Application No: M/86/20/PL
Site Address: 8 Manor Way Elmer Middleton-On-Sea PO22 6LA
Description of works: Demolition of existing 2 storey dwelling and construction of new 2 storey 4 bedroom dwelling with habitable loft and all associated works. This site is in CIL Zone 4 and is CIL Liable as new dwelling.

Thank you for your internet representation made on 8th December 2020 which has been recorded as an objection with the comments as follows:

Proposed Elevations

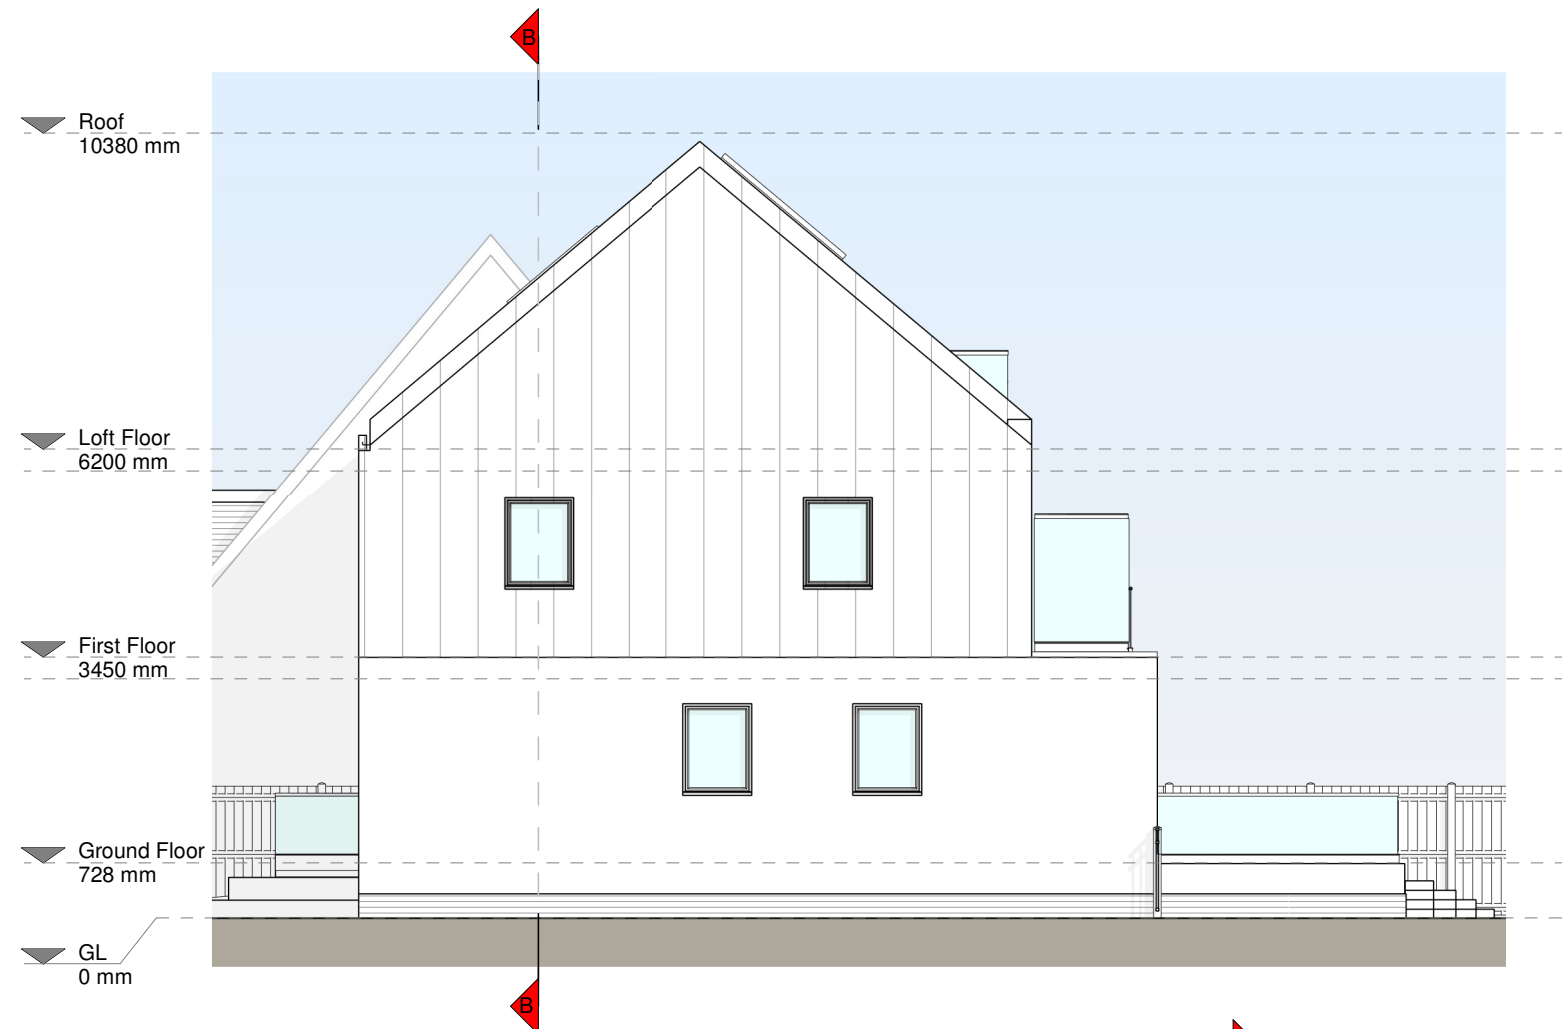
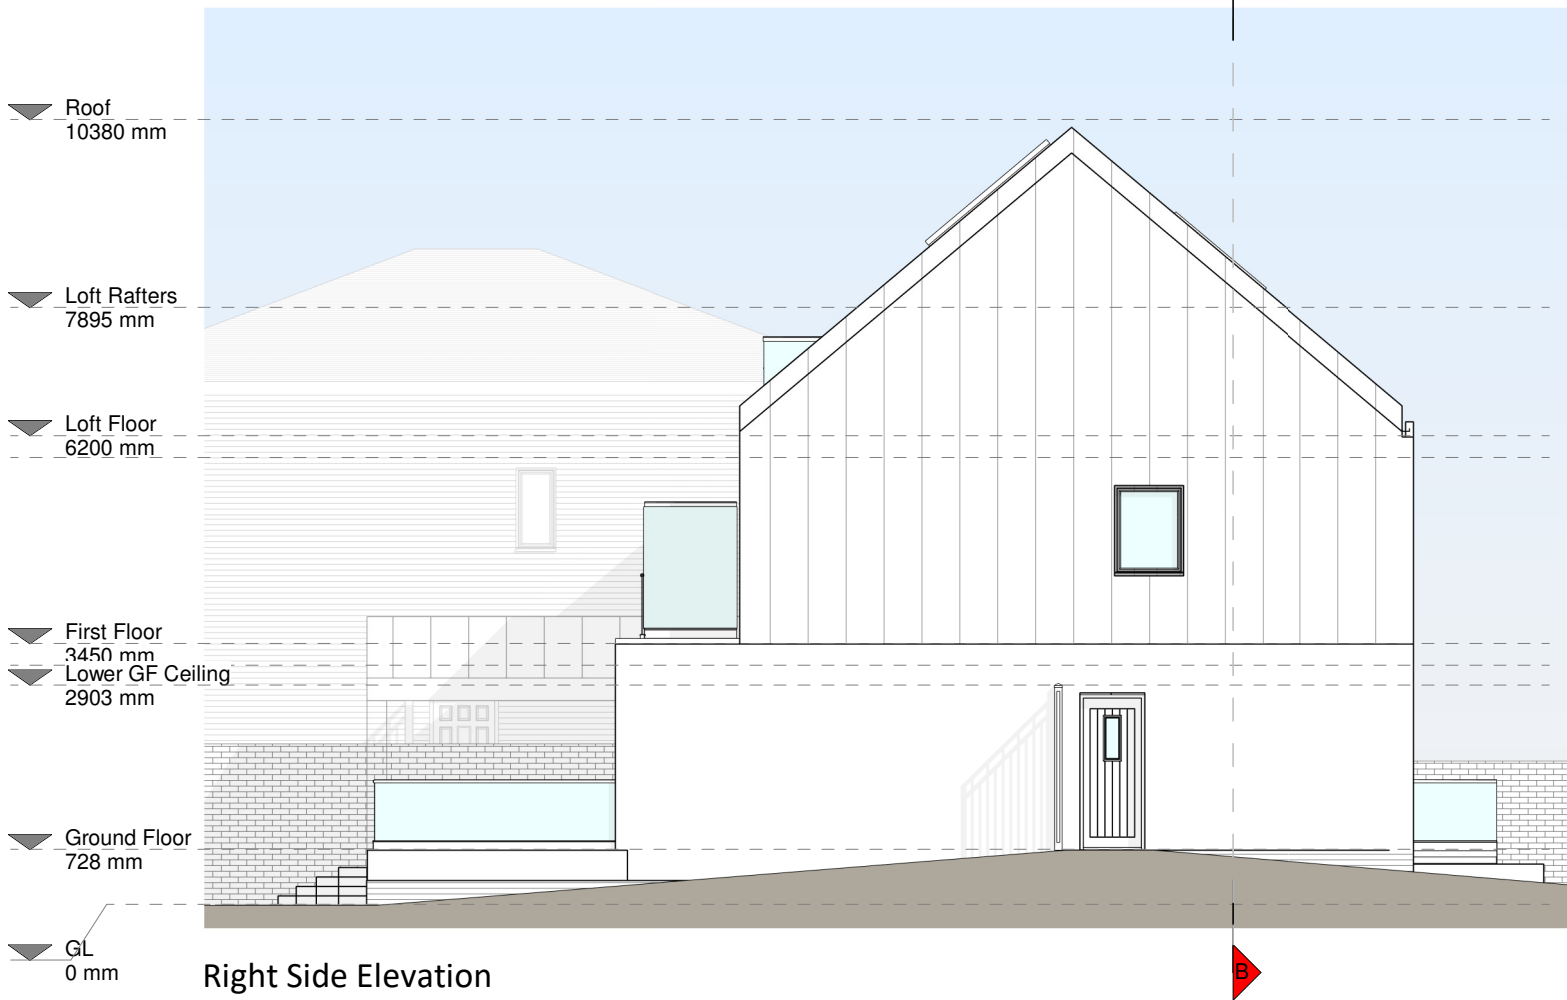
The height of the accommodation seems out of keeping with other buildings and is in in our sight line and would be the only three storey building in the area that I am aware of, except for the old coastguard station, three decks which is an historic part of the area.
